Our ref: HMS ID 6740

Exhibition of an Environmental Impact Statement (EIS) for the Junction Rivers Wind Farm (SSD-30448824)

As delegate of the Heritage Council of NSW, I provide the following comments:

Figure 4.16 Lynwood homestead in 1961 (top left), 1974 (top right), 1990 (bottom left), and 2018 (bottom right)

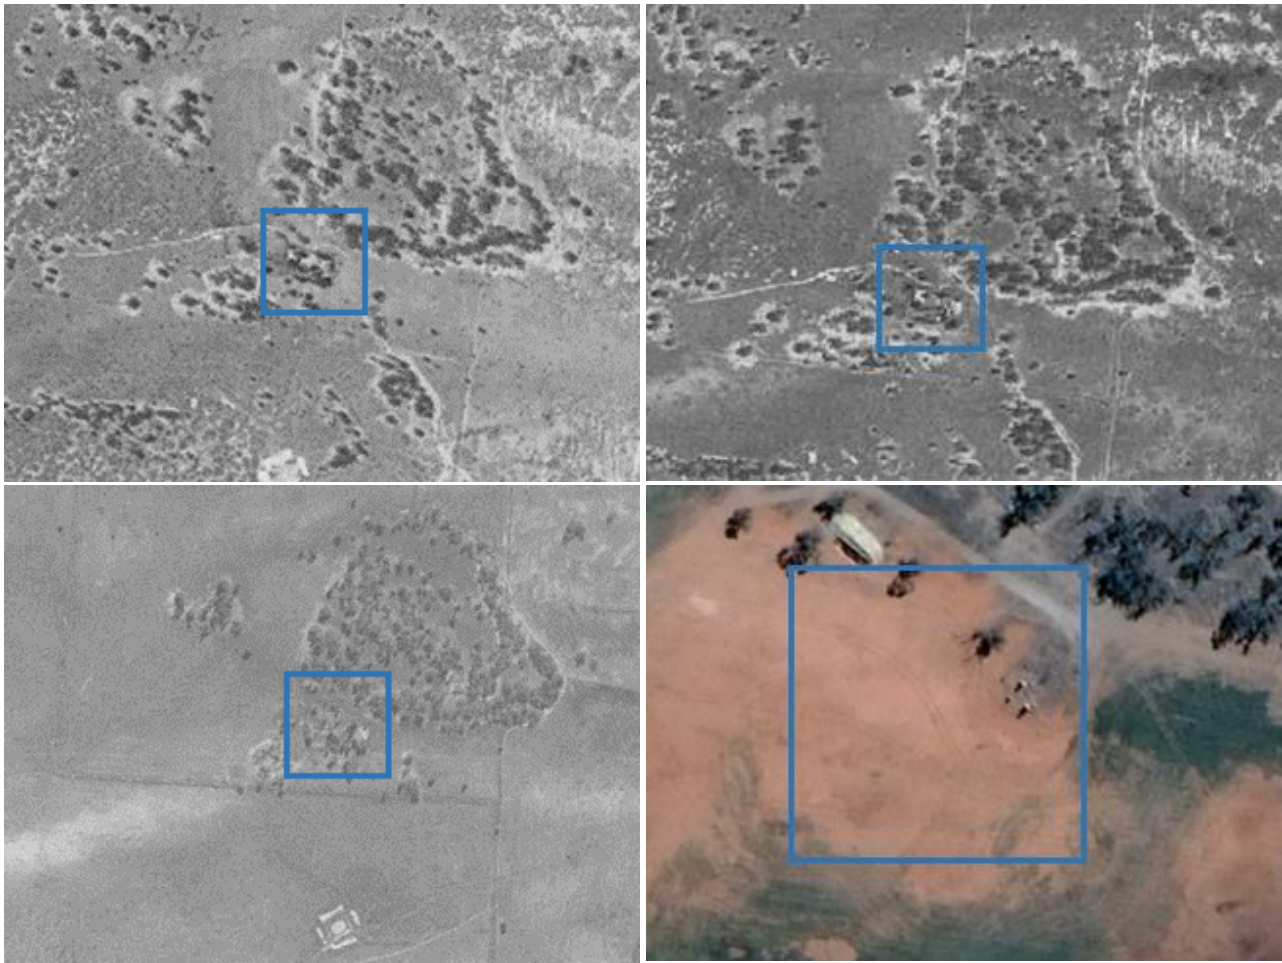
- The site is not listed on any statutory heritage list and is not within the vicinity of an item listed on the State Heritage Register.
- The *Historical Heritage Impact Assessment* (HHIA) has identified that the ruins/remains of three 1890s homesteads – Lynwood, Tyndale and Oldham Park – remain on the site. The HHIA states that the site has high potential to contain archaeological material relating to these homesteads. The HHIA has assessed that depending on the integrity and contents of the archaeological resources, these homesteads may meet the threshold for listing as heritage sites on the Local Environmental Plan. There is also potential for archaeological materials related to other aspects of the area’s history to be present.

- Exclusion zones are to be established around the ruins of the 19th century homesteads ‘Tyndale’ and ‘Lynwood’, as recommended in the HHIA. The exclusion zones are to be established prior to the commencement of works and are to remain in place until the completion of works. The boundary of each exclusion zone is to be defined with temporary fencing and the zones are to be clearly signposted. No works or related activities are

- A photographic archival recording of the remnant structures of 'Lynwood' 'Tyndale' and 'Oldham Park' is to be prepared prior to the commencement of works. The archival recording must be in accordance with the Heritage NSW publication 'Photographic Recording of Heritage Items using Film or Digital Capture' (2006). The digital copy of the archival record must be provided to the Department of Planning, Housing and Infrastructure prior to the commencement of works.
